**CITY OF ALBUQUERQUE
PLANNING DEPARTMENT
February 12, 2014
DRB Comments**

PROJECT # 1009956

APPLICATION # 14-70033

RE: Tracts A & B, Block D, Indian Acres

PLAT OF  
TRACTS A-1 AND B-1, BLOCK D  
INDIAN ACRES

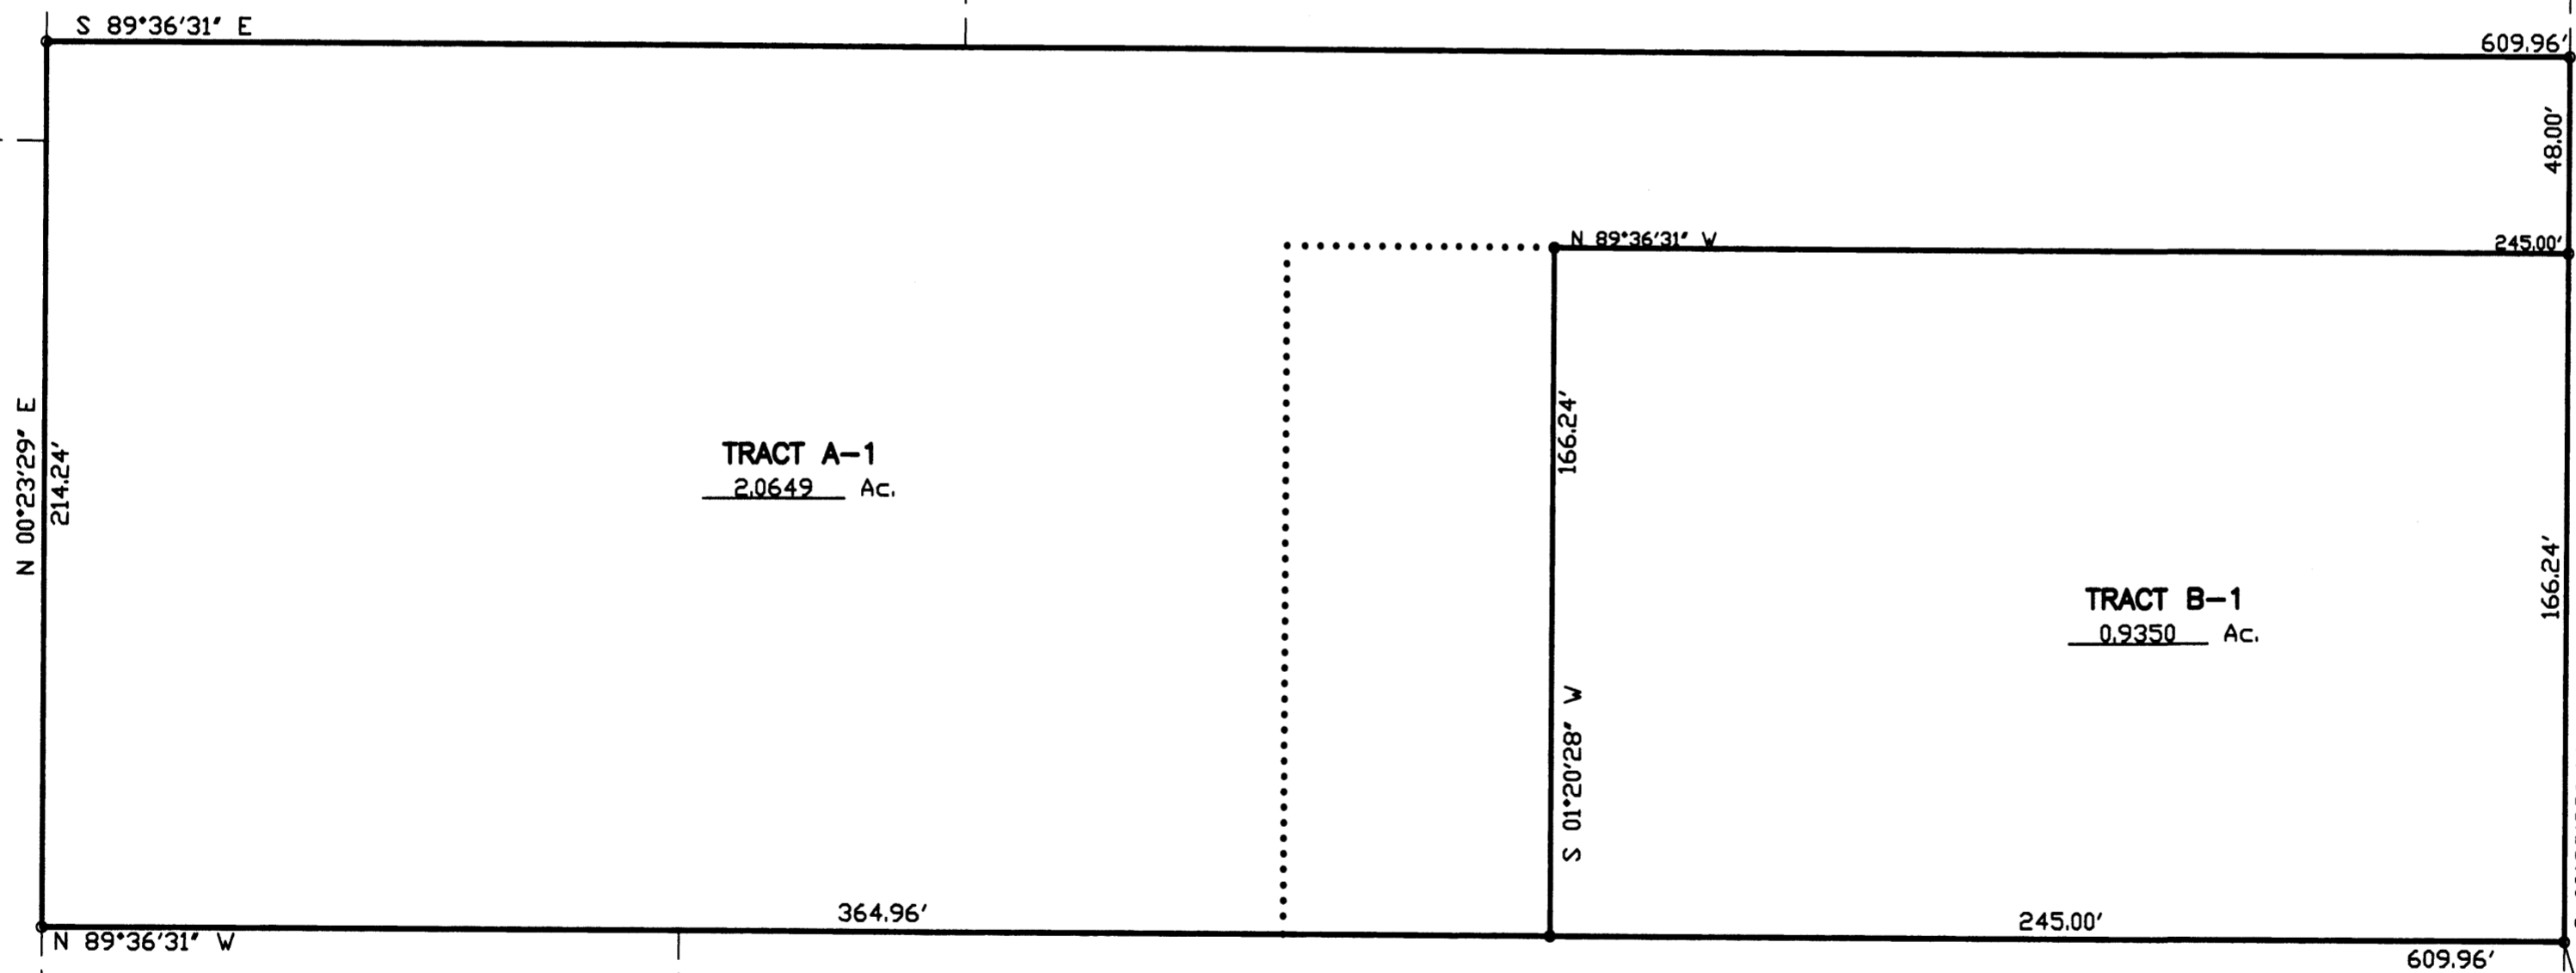
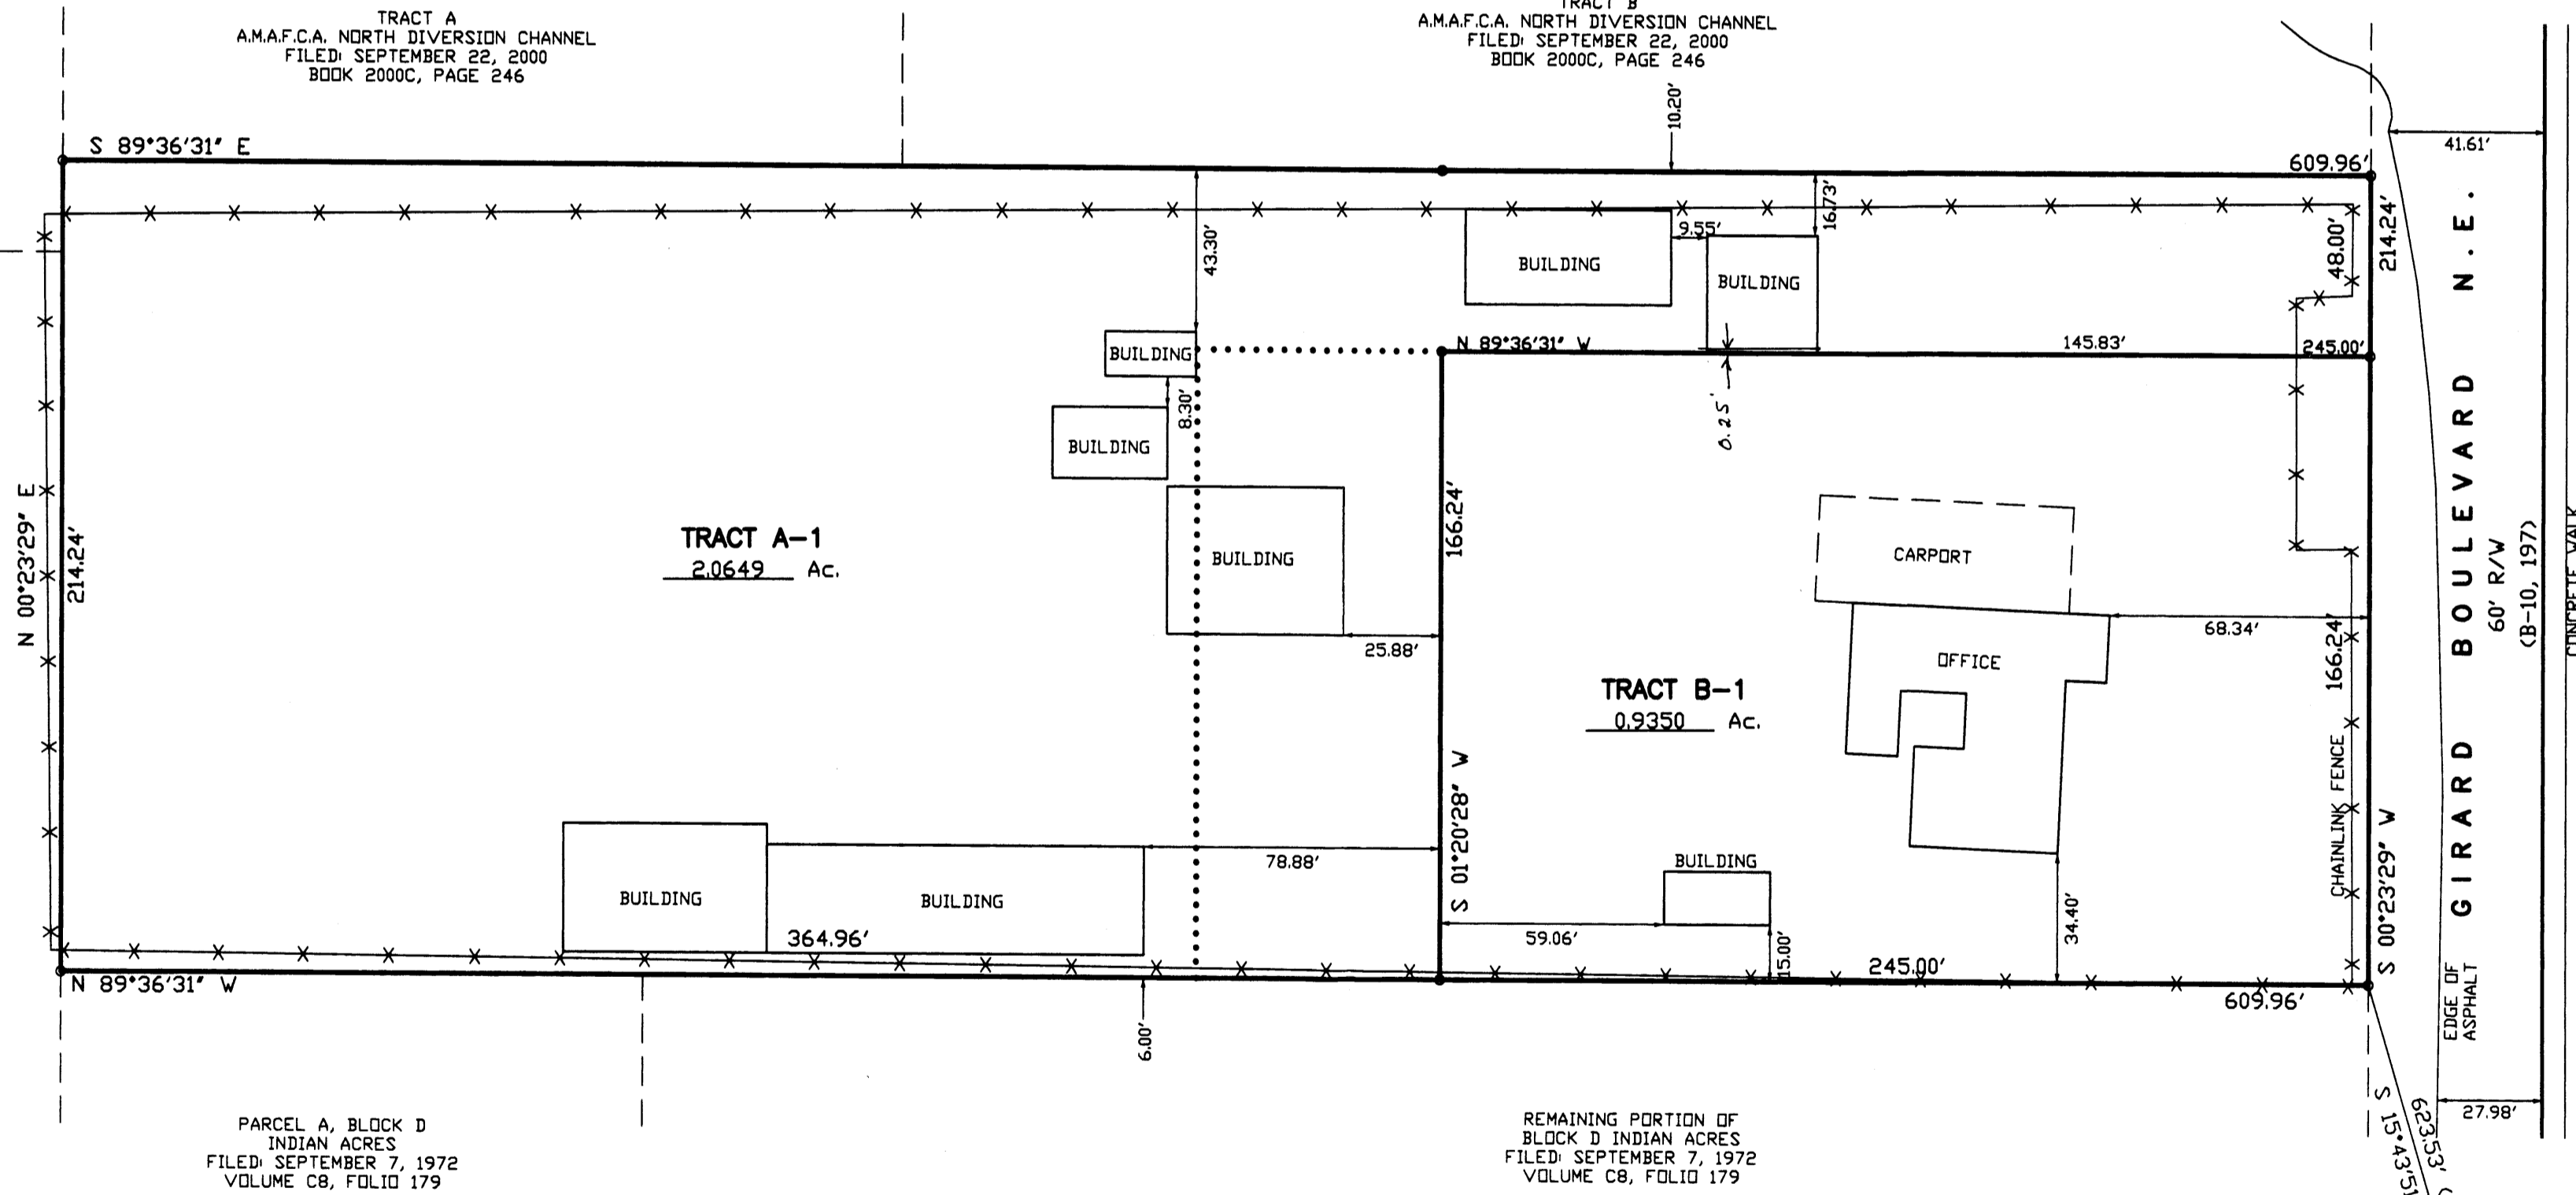
Scale and Graphic scale need to be corrected to conform with plat drawing, or vice versa.

Based on existing development, a shared access easement will be needed.

Based on existing development, a registered architect or engineer will need to verify that the westernmost building on Tract A complies with the building code regarding proximity to the interior lot line.
